**From:** [White, Lori \(ECY\)](#)  
**To:** [Kelly Bacon \(CD\)](#)  
**Subject:** Sweetwater site visit  
**Date:** Wednesday, July 14, 2021 10:18:42 AM  
**Attachments:** [image001.png](#)

Thank you for attending and arranging the site visit yesterday, July 13, 2021. While onsite we talked with the applicant and their agent. The agent discussed plan changes including the removal of parking lot B, which was located in an area of concern. Due to the time of the year, the site investigation focused primarily on the presence of hydric soils.

SITE PLAN

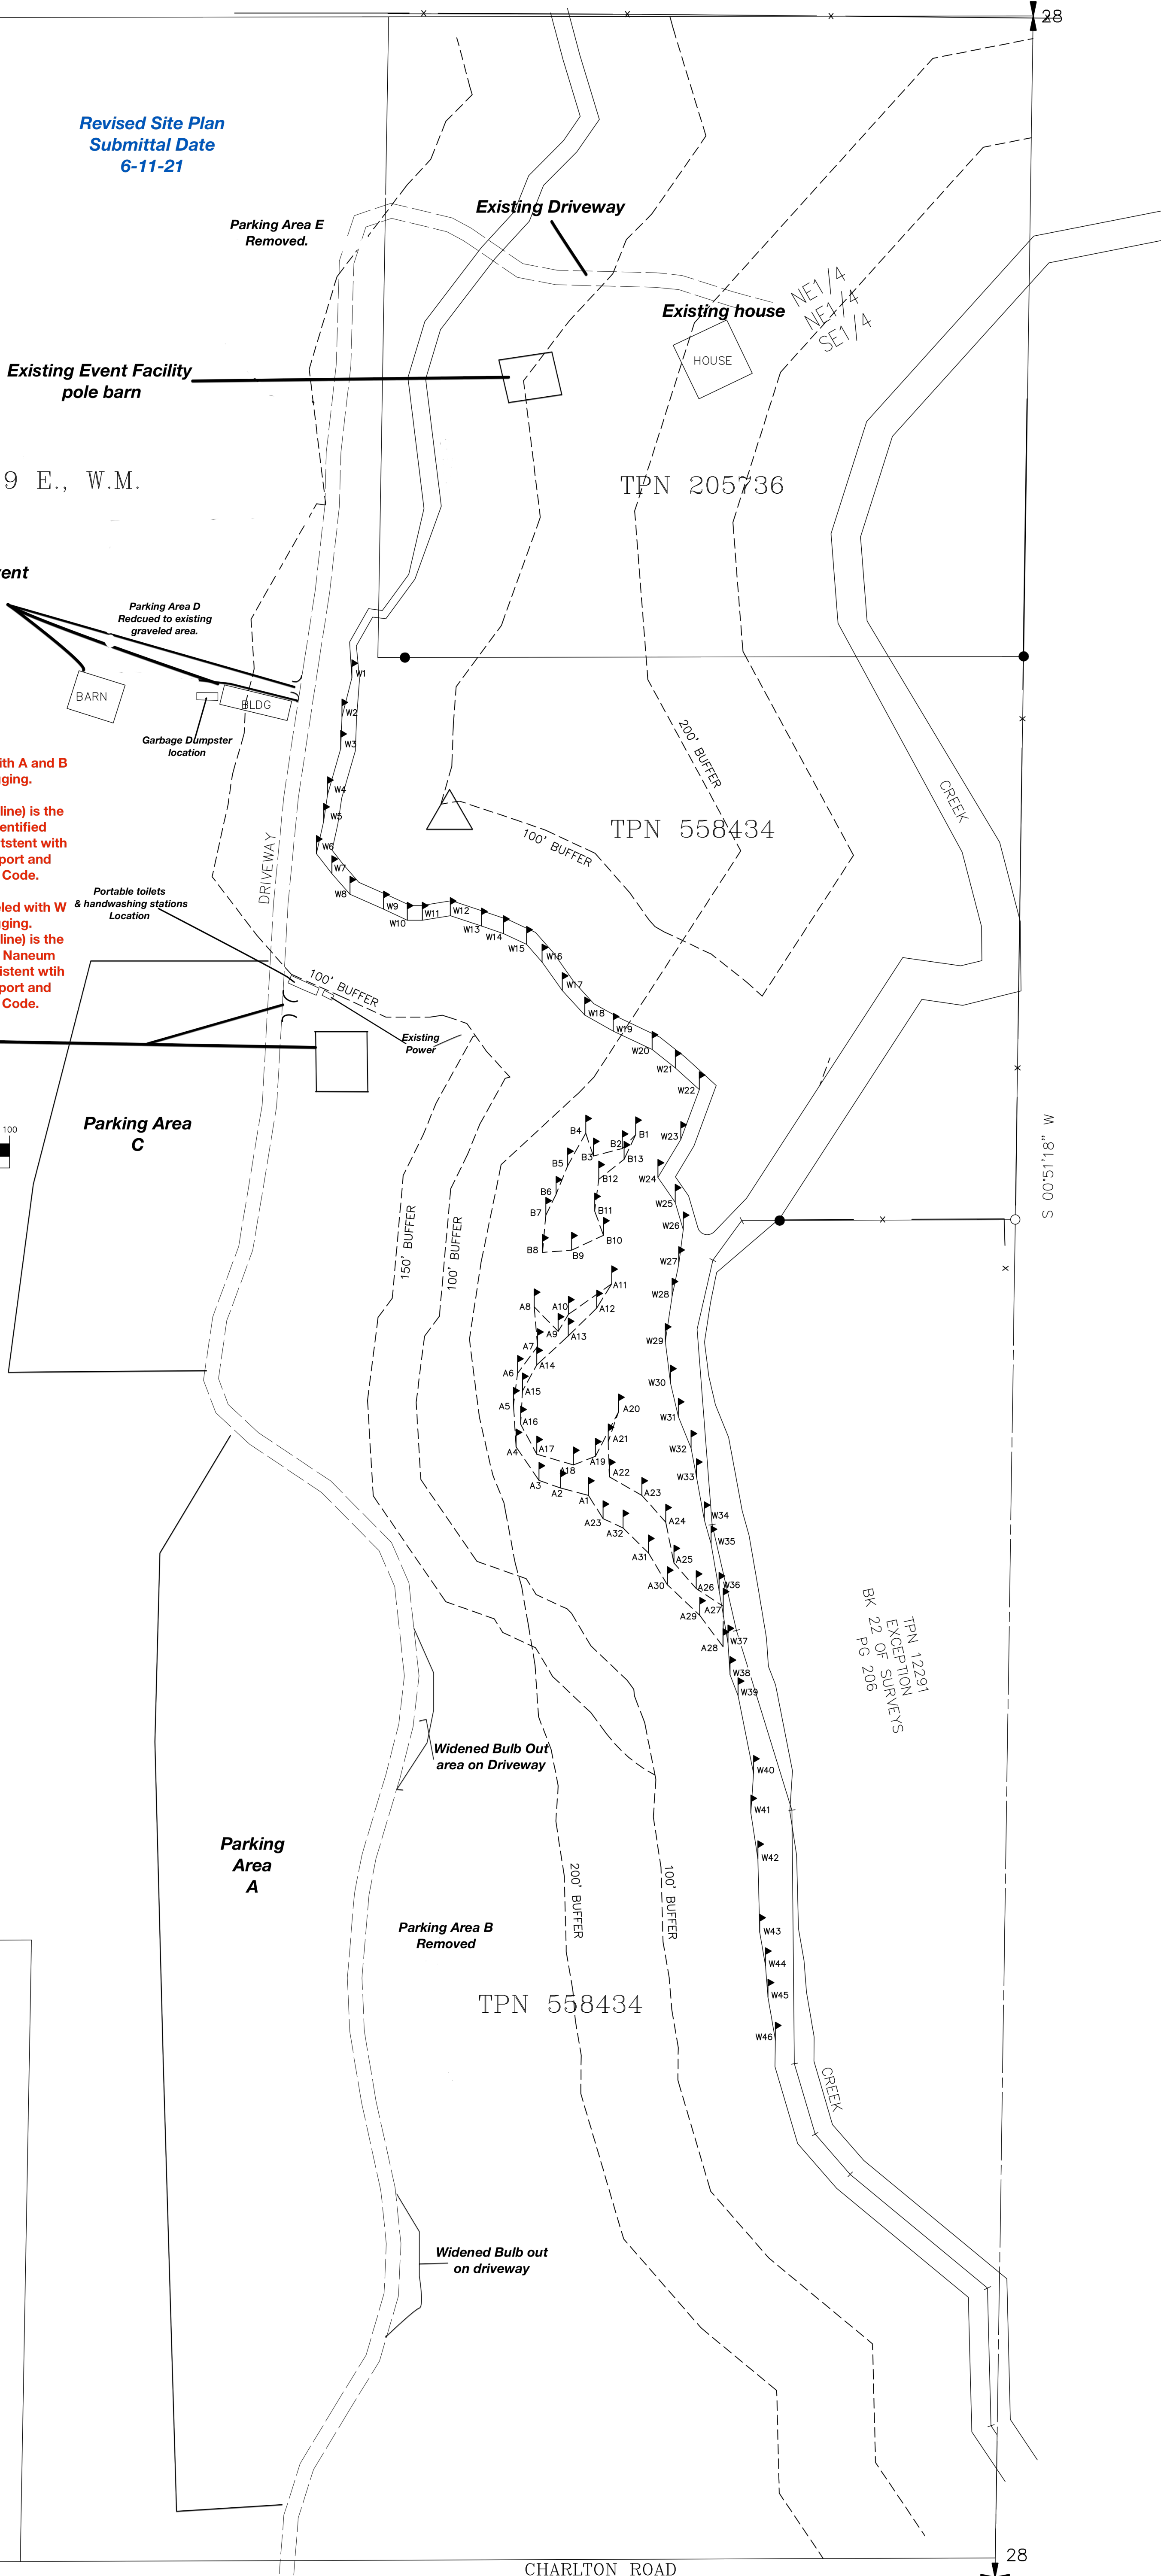
Ecology was present to review areas of interest, as a result of the review of Ed Sewall's 2019 wetland delineation. Four areas were outlined for review. Soil pits were dug in three of the four locations. Shovel refusal occurred at location 2 due to soil compaction (likely due to livestock) and cobbles. Each of the areas are detailed below and shown in the below map:

Area 1- Is located between Naneum Creek's riparian habitat and that of the nearby irrigation ditch, approximately within 100 feet of Naneum Creek. A small depression was noted in this area. Vegetation included horsetail, cottonwood seedlings, rush species, and various grasses. A dry, sandy loam substrate characterized by 10 YR 3/3 Munsell soil colors occurred in the top 8 inches of the soil profiles. Soil color changed below 8 inches and some redox was noted (~3%). Did not meet hydric soil indicators. Water is likely not staying in place long enough.

Area 2- Is located about 330 ft south of Area 1, near a large pine tree. Rush and various grass species were noted in this area. Soils were not able to be categorized due to shovel refusal.

Area 3- Is located approximately 100 feet south of Area 2, near Charlton Road. The area largely consisted of rush and various grasses. Soil was characterized as moist with the top 3 inches consisting of numerous fine roots and a 10YR 3/3 soil color. Soil below 3 inches had a color of 10YR 3/2 and prominent redoximorphic features consisting of at least 5%. The soil did meet hydric soil indicator F6.

Area 4- Is located west of the Irrigation Ditch in a small grove willows. Understory within the willows included upland species of snowberry, golden current, and rose species. Soil in this area was dry and characterized as 10YR 2/2 with no redoximorphic features noted.

Based on the information above, Area 3 should be further investigated for additional wetland characteristics. It would be in the applicant's best interest to have Mr. Sewall revisit the site and further investigate the areas mentioned for the three required wetland characteristics (hydrophytic vegetation, hydrology, hydric soils). Please note that several of the areas of interest are located within 200 feet of Naneum Creek (the OHWM was not determined nor were measurements taken onsite. Estimated on aerial images).
